Subject: FW: 40 little Paddocks

My apologies in the delay in getting a response in to you on this, as the product was unfamiliar it was prudent to research it thoroughly. As you can see from the e-mail below Paul (Principle Drainage Engineer) has discussed the product with Wavin and is of the opinion that it is not suitable for this site. We all share concerns that if the orifice became blocked the unrestricted flow rate would continue to the foul with no indication of blockage on site. Given Southern Water's concerns about flooding downstream and the obviously dire consequences of foul sewer flooding, this would not be an appropriate solution. Whilst flooding on site would be undesirable, it would be a clear indicator that a blockage had occurred and could be easily rectified. In our opinion this is a better outcome than the overflow proposed.

With regards to the rest of the application the layout is clear. We would prefer to see an inspection chamber at the 90degree junction south of CC2 (or the angle slackened). I have not checked the calculations as these may change with an alternative flow control device.

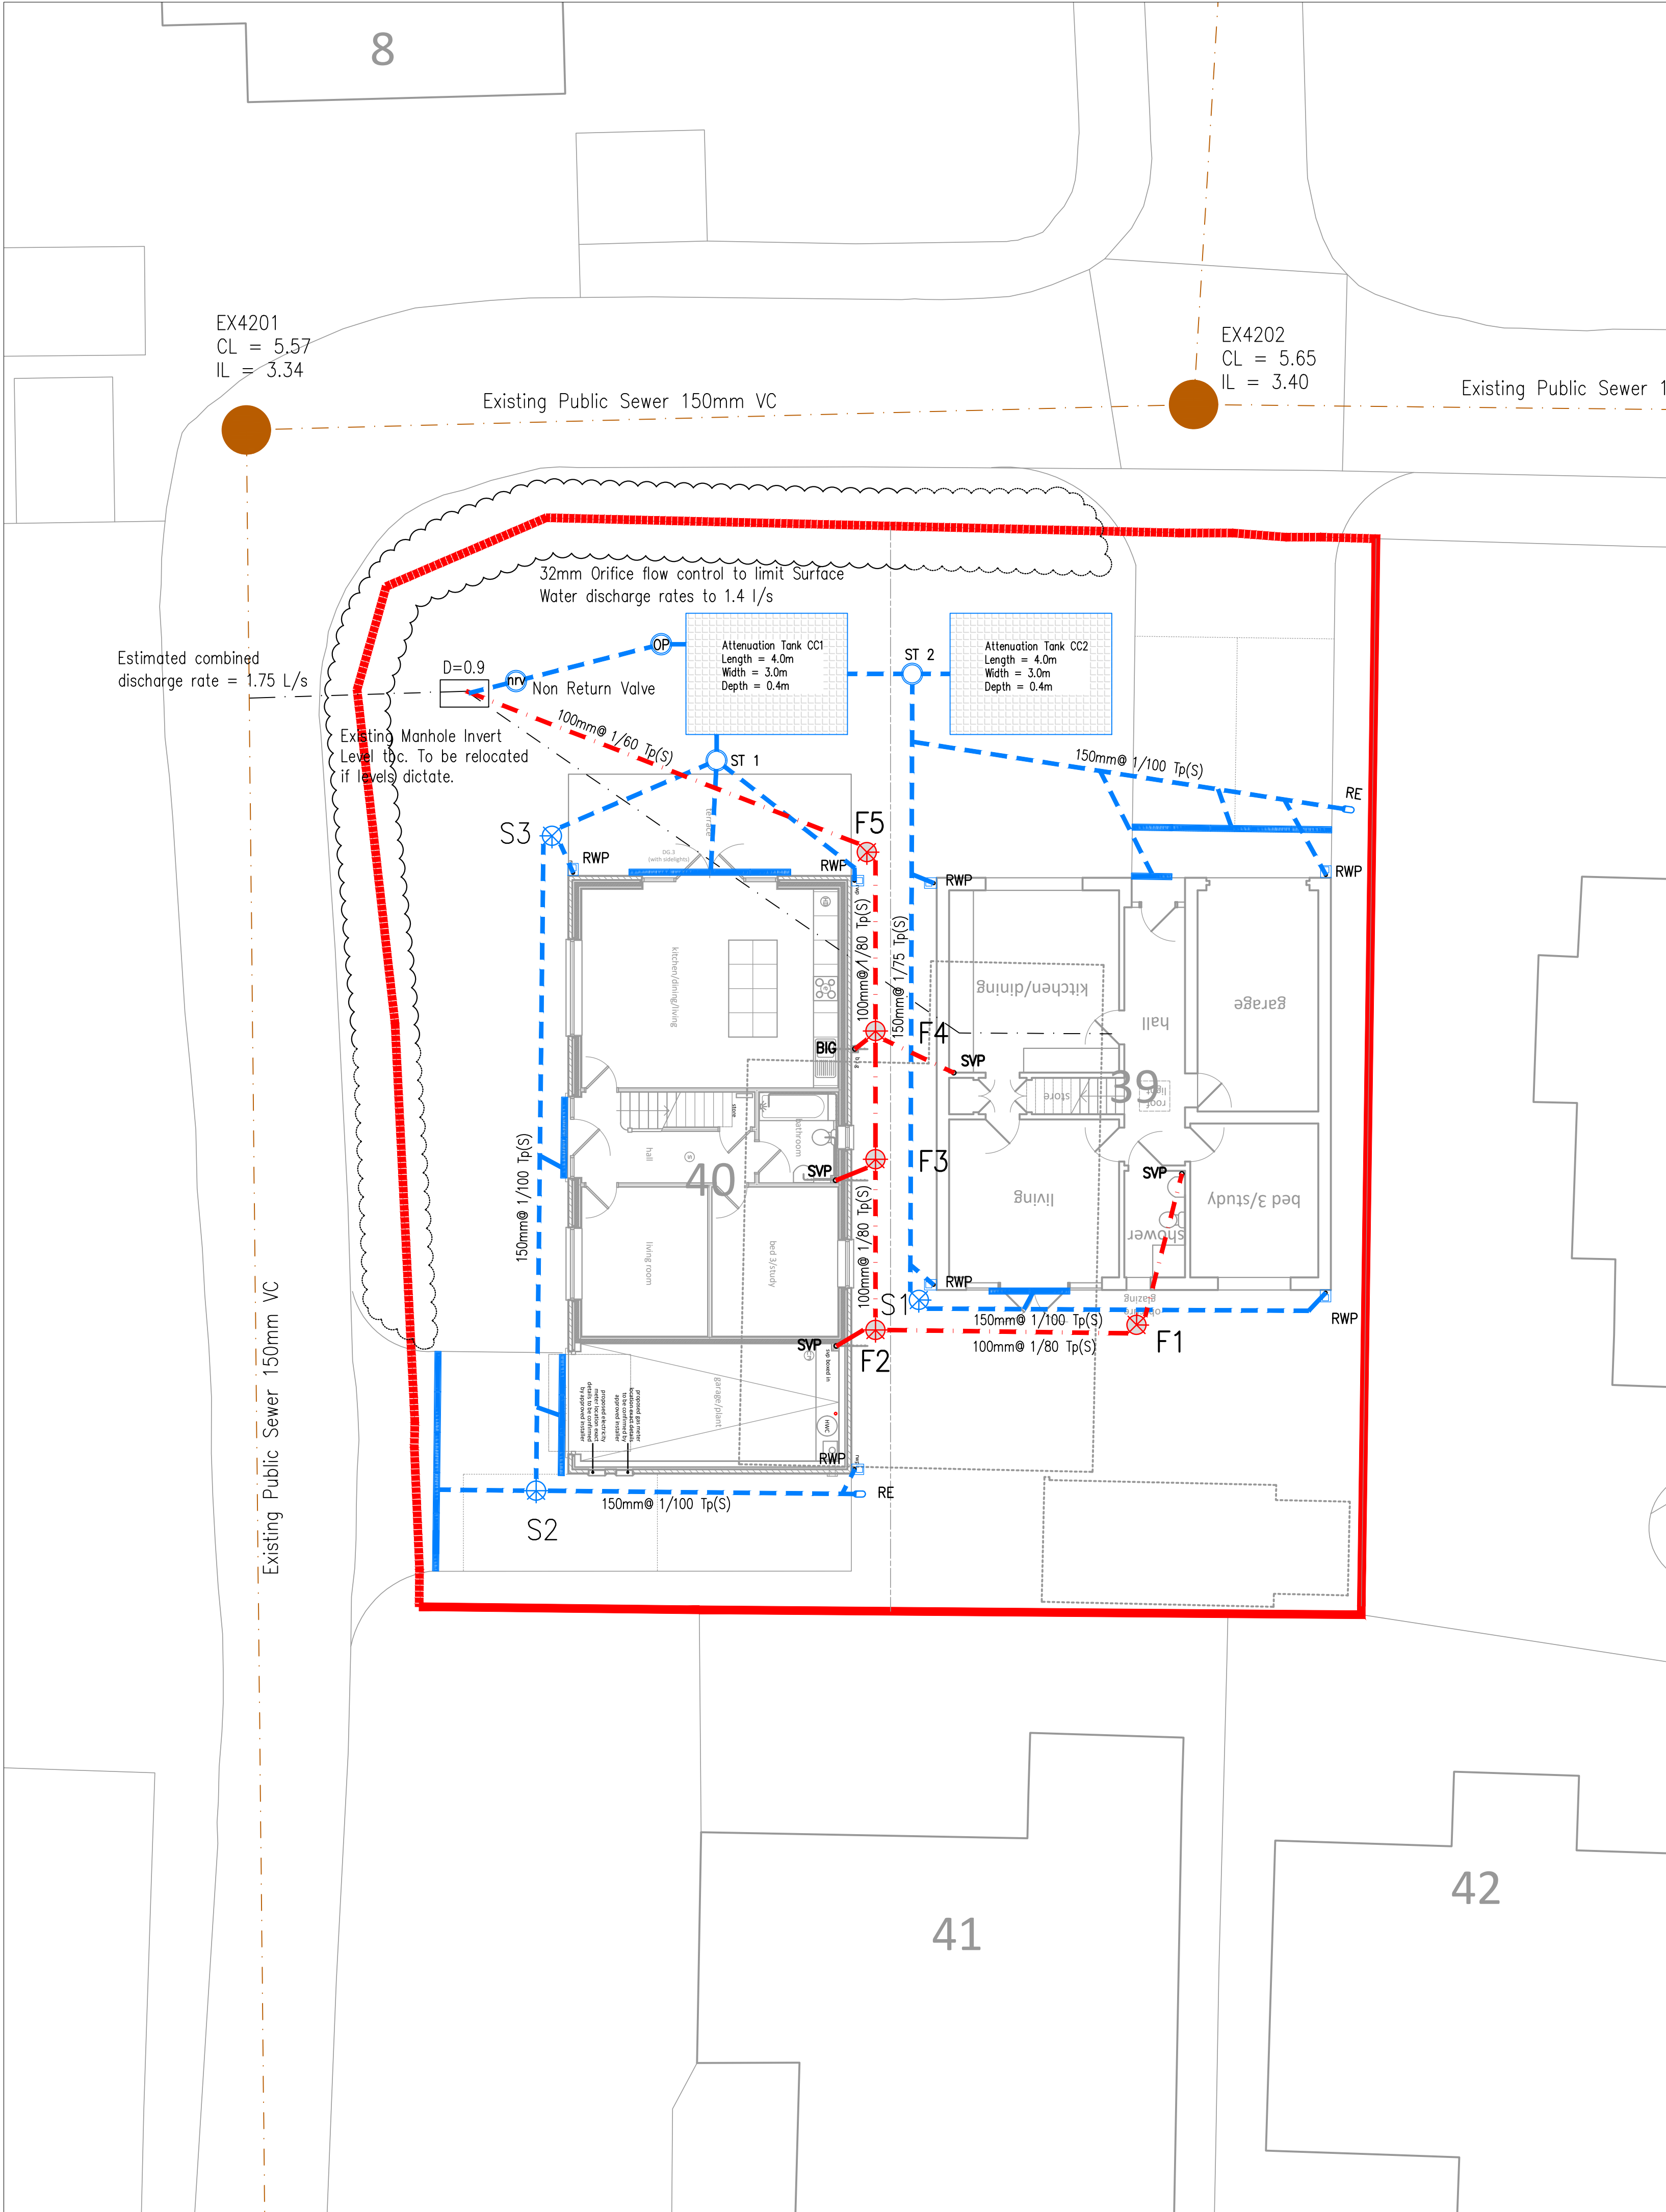
At present, your layout shows a single inlet to the garastor from the attenuation tank and a single outlet to the non-return valve. There is no outlet for the 150mm pipe (to go back to the attenuation tank) as that would be the same as the inlet. This is what I was referring to as an online vs offline system. In my rudimentary understanding of the system, on the basis of your descriptions and the Wavin documents, I would expect the network from the west property to discharge from ST1 directly to the garastor rather than via the attenuation tank. Allowing the garastor to then overflow via the outlet pipe to CC1.

Similarly I would have thought that the network from the eastern property would have to go to the garastor rather than via CC1. This could be achieved by locating ST2 on the pipe junction south of its current location and then connecting ST2 to ST1.

Polypropylene Orifice Flow Control Chamber

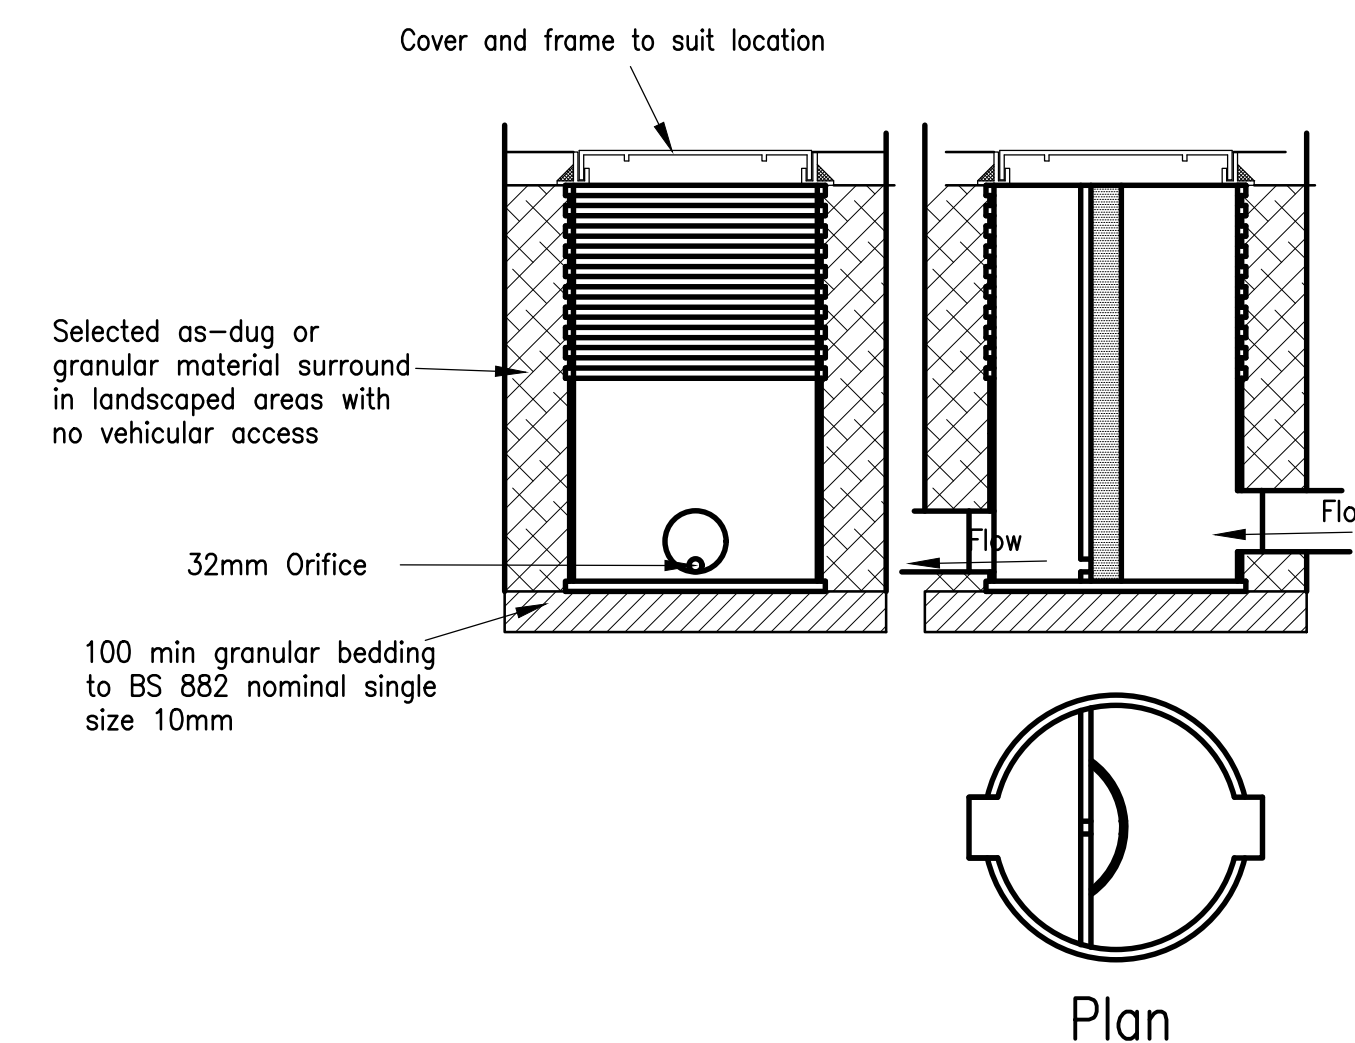
I have spoken to Wavin. See page 24-27 of attached. The orifice (whilst not shown) is located on outside of the 90 degree bend at the bottom of the overflow.

As discussed, we would not want an overflow arrangement of this type whereby we don't know if there is a blockage (especially as this is connecting to the foul and we/southern water would not want full flows bypassing the orifice).

There is also nothing to protect the orifice from blocking (Wavin acknowledged this), unless a filter arrangement is installed immediately upstream.

In short the product is not acceptable for use in this particular situation.

Thank you for the updated calculations. I shall check them shortly. Before I do that can you clarify something for me? I have looked at the Wavin garastor and the construction detail drawing, both imply the system would be offline. The 'weir' system which would help to mitigate blockage seems to apply in the incoming pipes and then the lower pipe to the attenuation system is free flow. On your drainage layout Attenuation Tank CC1 is online. Therefore would the weir system not operate? Or would you link in the attenuation tank to one of the inlet pipes with the outlet blocked?

Furthermore it is still unclear from the drawings and product information the exact location of the orifice within the system and how water drains before the overflow grill 'hat'. I have discussed this with the Principle Drainage

Engineer (Paul Cann - copied in) and he is also unfamiliar with the system. We have agreed that the best way to approach it would be to provide a site specific construction detail drawing including levels. Please can you provide this at your earliest convenience.

The garastor is a purposely designed flow control chamber, which has twin chambers. The inner chamber being 400mm high. This then operates like a weir, where flows exceed the 400mm storage height in the crates.

The incoming water freely discharges into the inner chamber of the garastor and discharges via a 34mm orifice into the outer chamber at base level, the outfall from the outer chamber is via a 150mm diameter pipe.

When the inflow exceeds the outflow, the inner chamber fills and allows water to back-up into the crates, the outflow from the inner chamber to the outer chamber being throttled to 1.4l/s and will not overflow until it breaches the weir height/crate depth. Whether inline or offline flows are restricted to a maximum of 1.4l/s in normal circumstances.
